Application Reference Number:		2024/1040	
Application Type:		Householder	
Proposal Description:		Single storey rear extension with wraparound to side elevations	
Location:		Cherry Tree House, 57 Hay Green Lane, Birdwell, Barnsley, S70 5XA	
Applicant:		Dr Lyn Sutcliffe	
Third-party representations:	Four from 2 no. addresses	Parish:	None
		Ward:	Rockingham

This planning application seeks householder planning permission for the erection of a flat roofed single storey rear extension to the dwelling with wraparound to the side elevations. The application was amended from an initially proposed two storey rear extension also coving the full width of the dwelling with a flat roof and proposed terrace.

Proposed Roof Plan

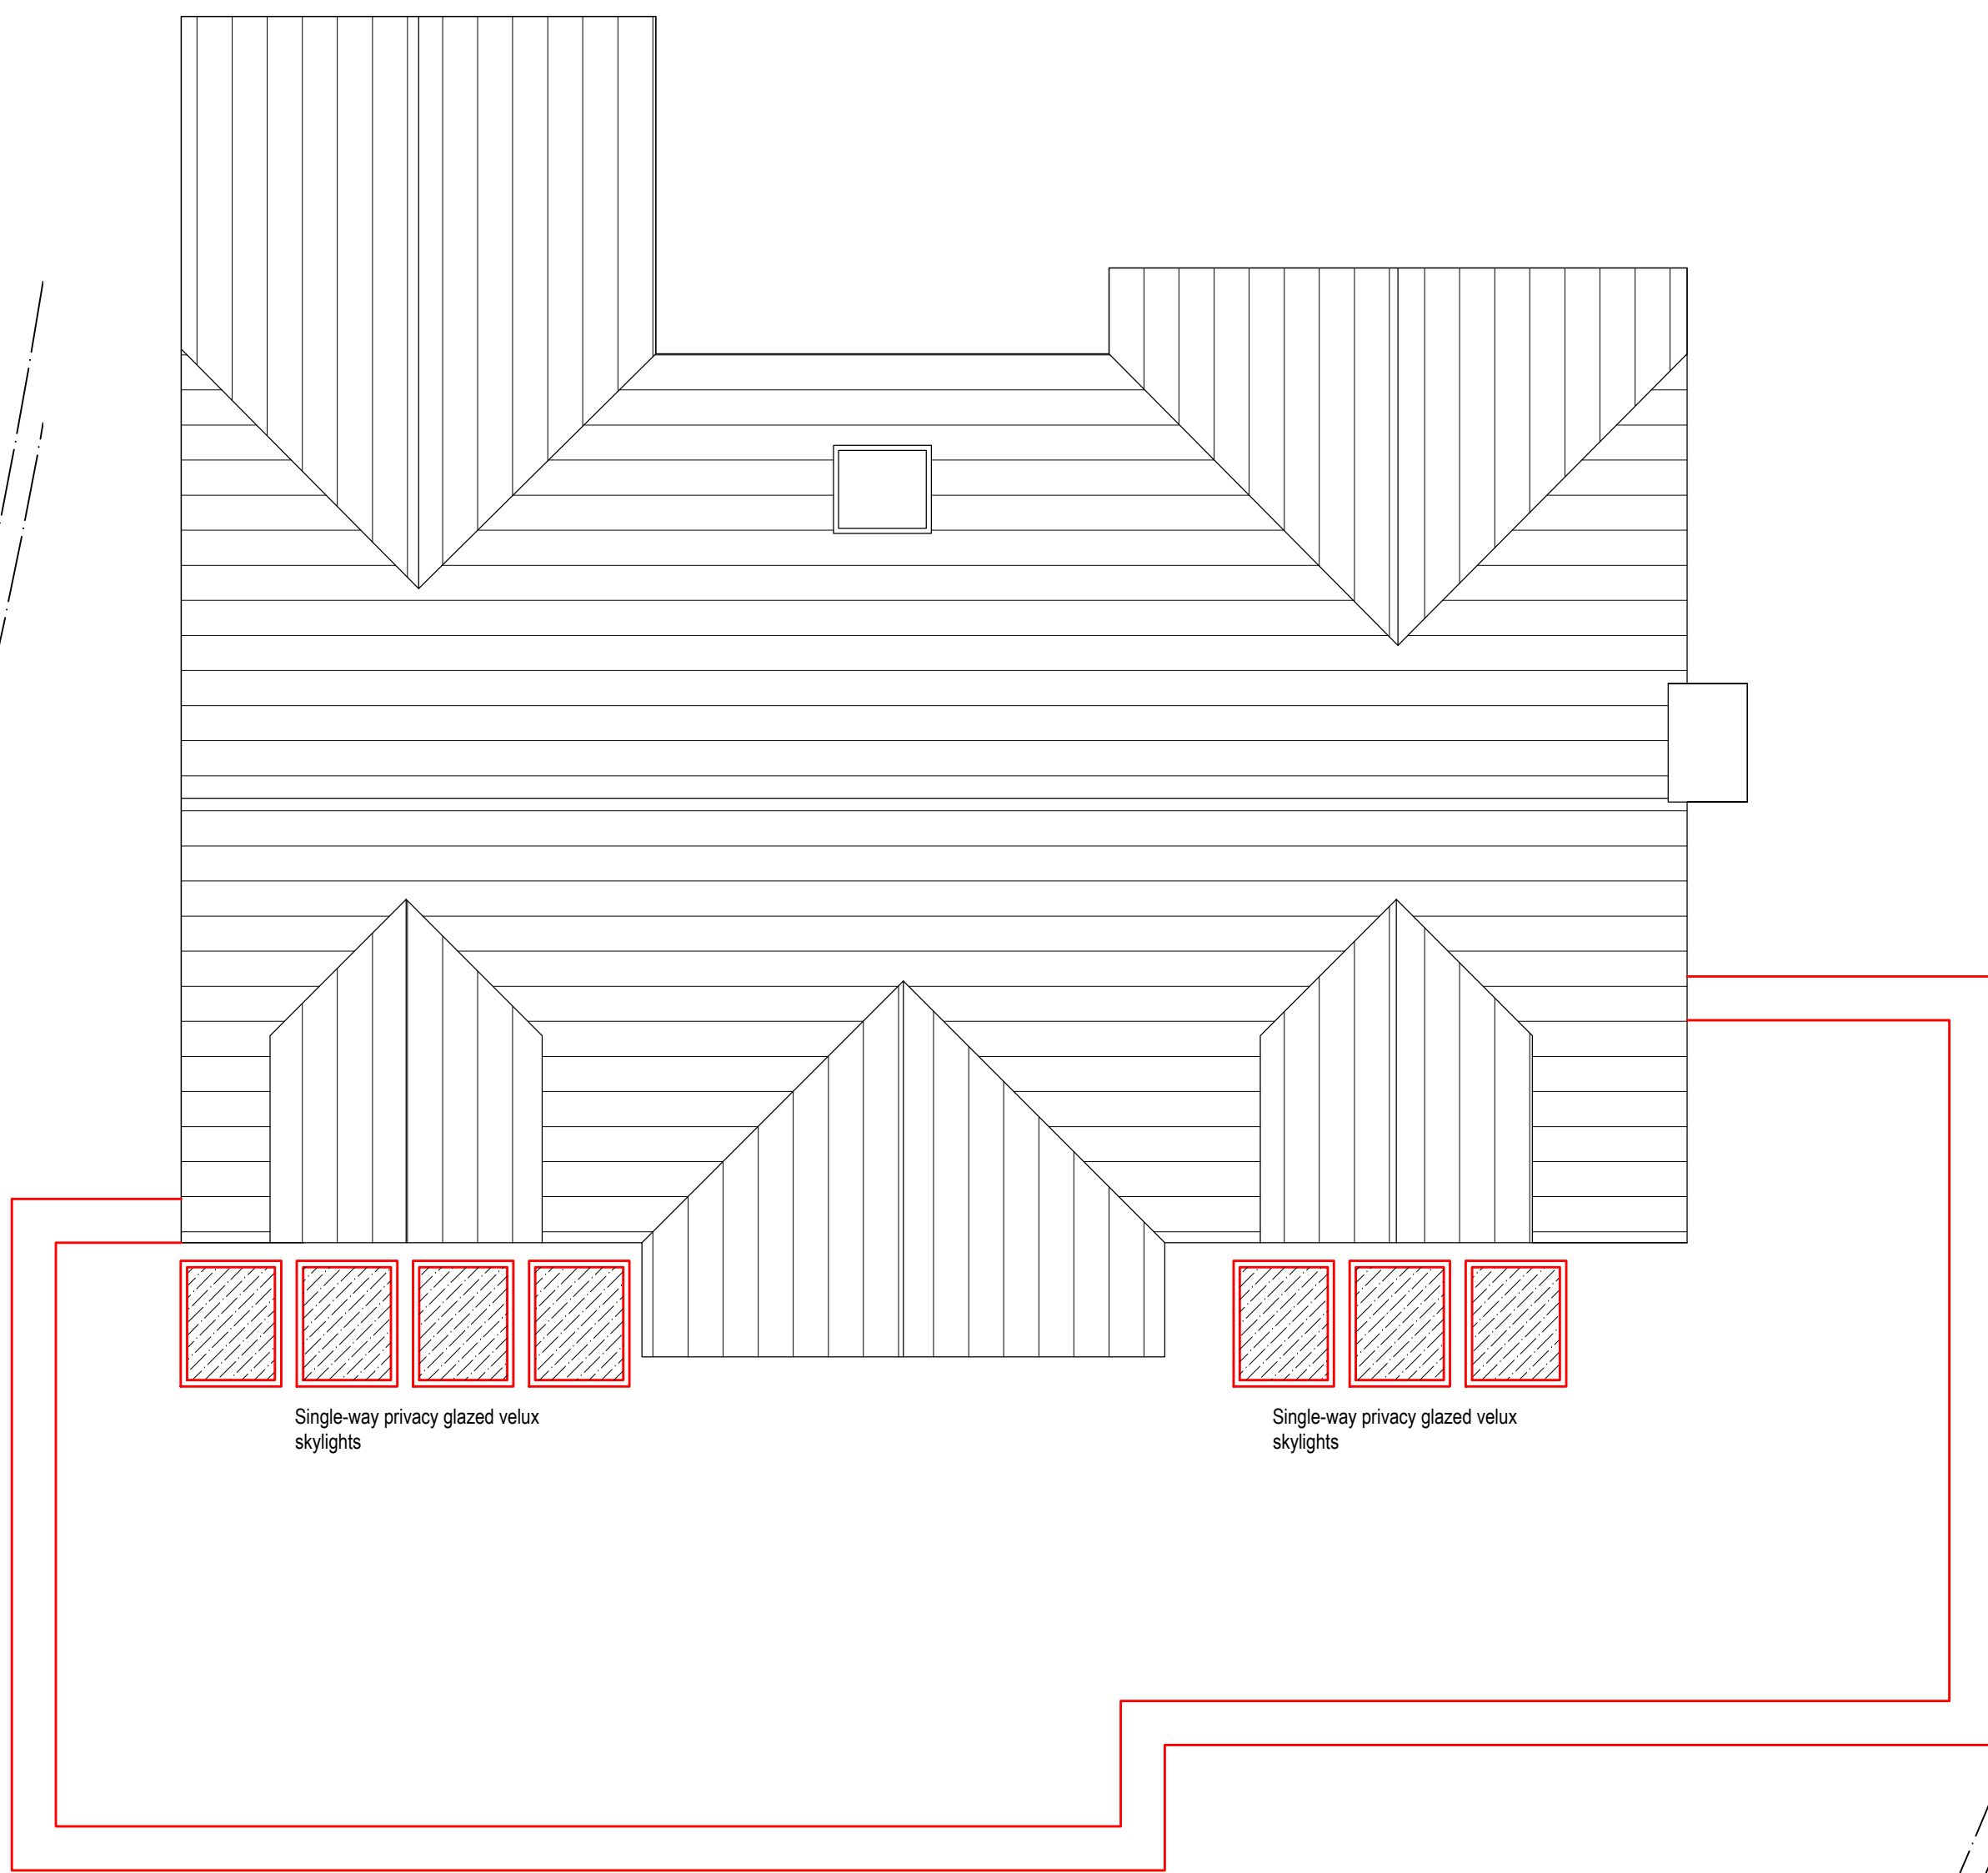
The SPD states that *“extensions to the rear of detached houses will be considered on their design merits and where no adjacent properties are affected”*. The design is relatively in keeping with the existing dwelling and the extension has a maximum rear projection of 5.05 metres. The side projections are modest and significantly less than two thirds the width of the existing dwelling.

Whilst objections were raised in relation to overlooking, overbearing and loss of sunlight and privacy, the proposed extension would not have a significant detrimental impact on any neighbouring property due to its appropriate proportions and modest projections which are deemed acceptable for this large, detached dwelling which is compliant with the adopted spd. The extension is not considered to be of an excessive size or scale and is an extension of the existing building form rather than a separate, stand-alone addition and is therefore subservient to the existing dwelling. Equally, it is not considered overbearing due to its restrained size and massing especially in relation to the initial proposal which was of two storeys. This weighs significantly in favour of the proposal.

As the extension is only of single storey, overlooking will be limited even with the addition of patio doors to the rear elevation, as they predominantly look onto the host dwelling's garden area. It is acknowledged that introduction of these could potentially increase levels of overlooking over the existing of the neighbouring dwellings, however with the existing tall fence providing adequate boundary treatment it is considered that the levels would not be harmful. This weighs modestly in favour of the proposal. The proposal is considered to be in compliance with Local Plan Policy GD1: General Development and is acceptable in terms of residential amenity.

The SPD states that *‘materials should normally be of the same type, colour and texture to the existing house or as close a match as possible’*. In this case, the proposed materials will match the existing dwelling with matching stonework to be used. The proposed roofing materials whilst not matching

The extension utilises a flat roof which is normally accepted as it can be an inferior form of construction. However, the extension is of a modern orangery style and is set to the rear of the property. A flat roof rear extension is already present to the rear of a neighbouring property (55 Hay Green Lane) which is also visible from the properties to the south and would therefore not impact additionally to a significant degree on the character of the area. As the extensions would only very slightly extend beyond the side elevations its impact on the existing streetscene would be very minor. This weighs moderately in favour of the proposal.

- Alterations to extension reducing height by reducing the proposal from two stories to a single storey and omitting the terrace
